Greg Burgon
11 Henry Kendall Crescent
Mascot NSW 2020

**Re: Objection to the proposed State Significant Development
Botany Road, Mascot, Affordable Housing (SSD-72393459)**

Figure 2 Floor Plan - Ground Floor

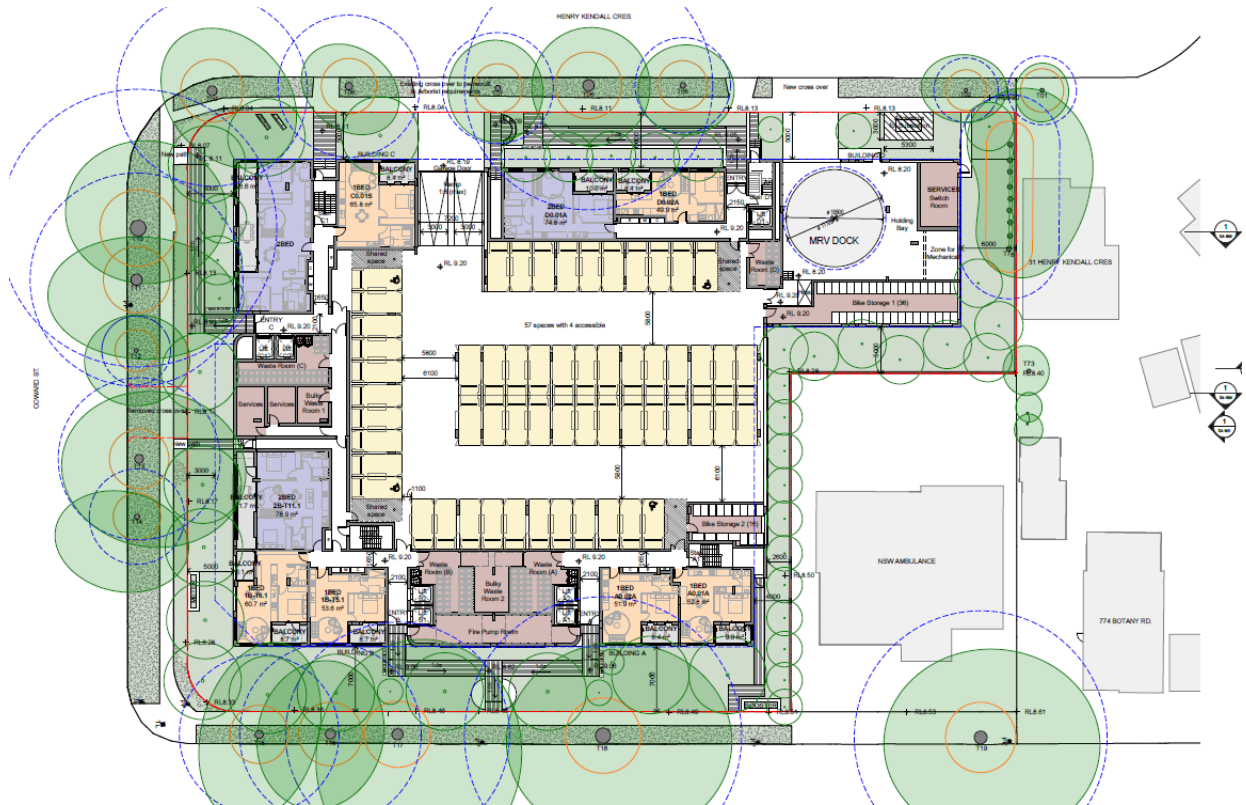
- 1. The design of ground floor apartments, with enclosed balconies and no apartment entrances from the street, results in an unacceptable interface with the public domain, detracts from the local character, is undignified for tenants and is inconsistent with good design principles for Social Housing.**

The proposed enclosed balconies / winter gardens for ground level apartments, lack of ground floor private garden space in the 7m setback zone, and no private entries to the apartments from the street creates an unacceptable interface to the public domain and is inconsistent with *Good Design for Social Housing* (NSW Government Architect, 2020). The proposal also misses an opportunity for passive surveillance / eyes on the street.

Recommendation: Provide ground level entries to ground level apartments, with their own private open space / garden facing the street.

5. In-active ground level frontage to Botany Road and Coward Street and location of waste rooms next to lobbies are results in an unacceptable interface with the public domain, detracts from the local character, is undignified for tenants and is inconsistent with good design principles for Social Housing.

Placement of garbage rooms at street frontages makes the buildings uninviting is a poor interface to the street. It is made worse that the building entrances are next to the garbage rooms. The elevation from the street shows approximately 1/3 of the elevation is non-active. Additionally, the bins have to be wheeled past the lobby to access the MRV doc / holding bay.

Recommendation: move these in-board so that apartments and lobbies face the street, and that bins are not near the entrances / lobbies.
